Consultation Response from KC Conservation and Design
2019/93488 3, Two Gates, Holme Lane, Slaithwaite, Huddersfield, HD7 5UG
Listed Building Consent for erection of two storey side extension and detached garage, demolition of existing garage and side extension
Date Responded: 27/11/19
Responding Officer: Craig McHugh
Responding Ref: CV 5/169
Summary

| Rev   | Date | Initial |
|---|------|---------|
| Proposed Garage/Workshop<br>Floor Plan & Elevations         |      |         |

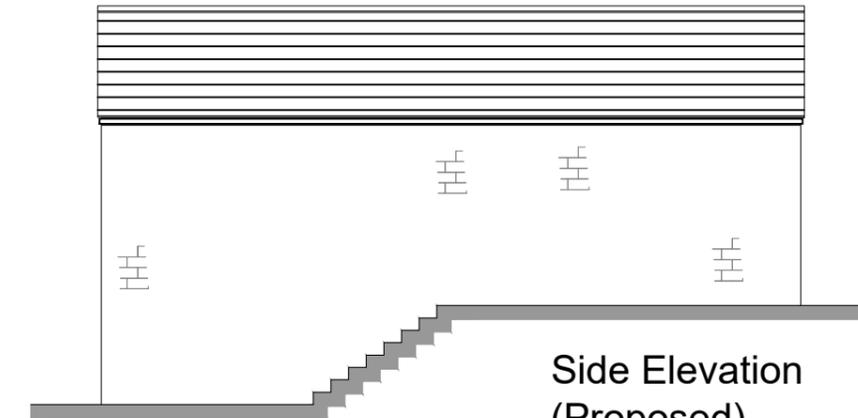
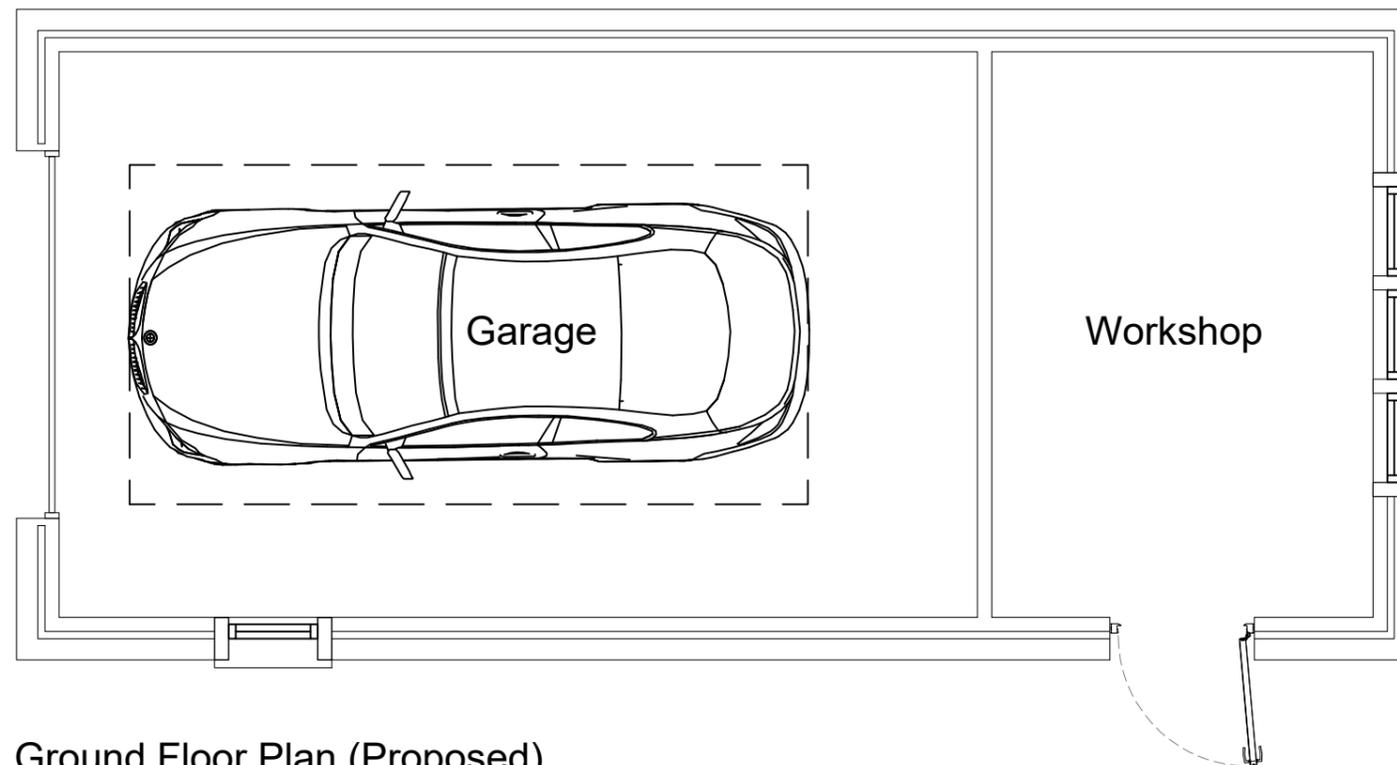
The demolition of the existing modern garage would be beneficial to the setting of the listed building. The new garage is of a substantial size and may impact on the visual relationship between the former farm house and the farmland beyond.

The impact of the proposed development on the setting would be neutral. The demolition of the modern garage would be beneficial but its replacement with a larger structure set further back may impact on the visual relationship between the former farm house and the farmland beyond.

Drawing
**Proposed Floor Plans, Elevations
& Site Plan**

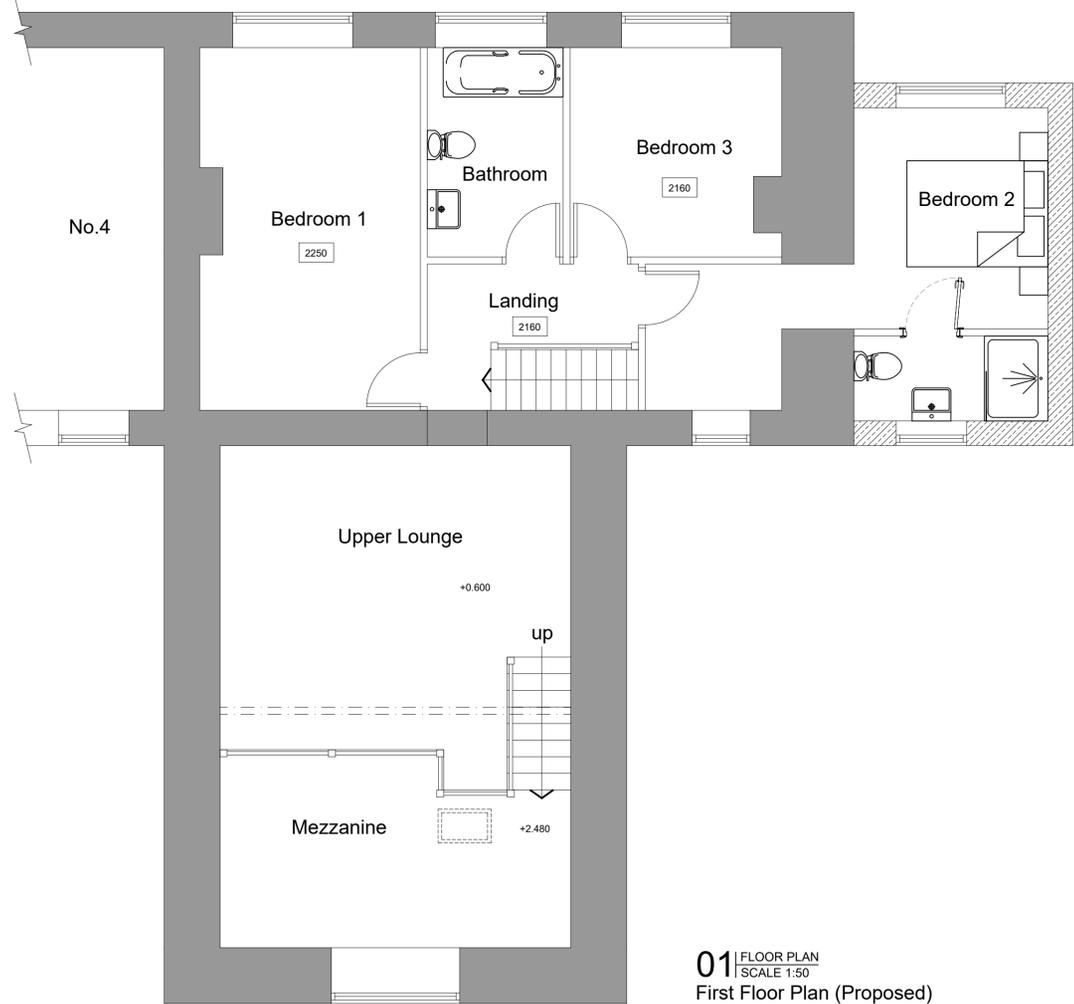
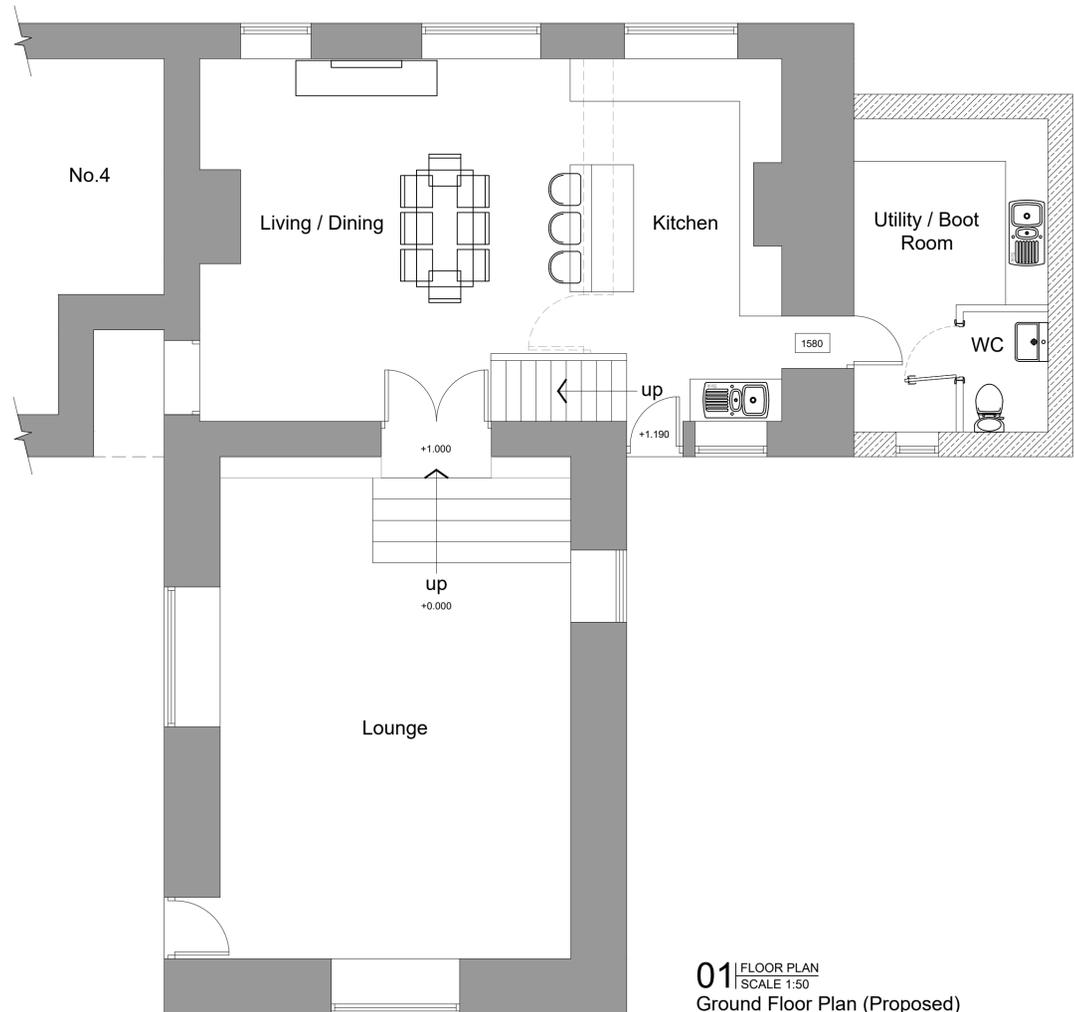
Notwithstanding the lack of submitted information, it is apparent that there are several aspects of the proposals that would cause harm to the significance of the listed building. The complete removal of the load bearing wall to the ground floor would substantially alter the plan of the building and would appear to result in the loss of the historic ceiling beams since they would have nowhere to rest. The gable window would be blocked by the new extension.

The opportunity should be taken to reinstate the chimney previously removed without listed building consent.

The proposed internal alterations would cause harm to the significance of the listed building by altering its floor plan. The impact of other internal works including the removal of the stairs cannot be assessed on the basis of the information submitted. Demolition of the existing lean-to extension and replacement with that proposed would have a neutral impact.

Paragraph 190 of the NPPF requires that we avoid or minimise any conflict between the heritage asset's conservation and any aspect of the proposal. Harm to the interior of the listed building should be minimised through amendments to the proposed layout.

The ground floor layout should be revised to retain the existing historic ceiling beam, at least part of the load bearing wall should be reinstated to support them and to indicate the layout of the listed building.

The unauthorised works to the chimney should be reinstated whilst the works to the extension and gable wall are being undertaken. This is described in the list entry as an 'Ashlar chimney to western end' and is illustrated below
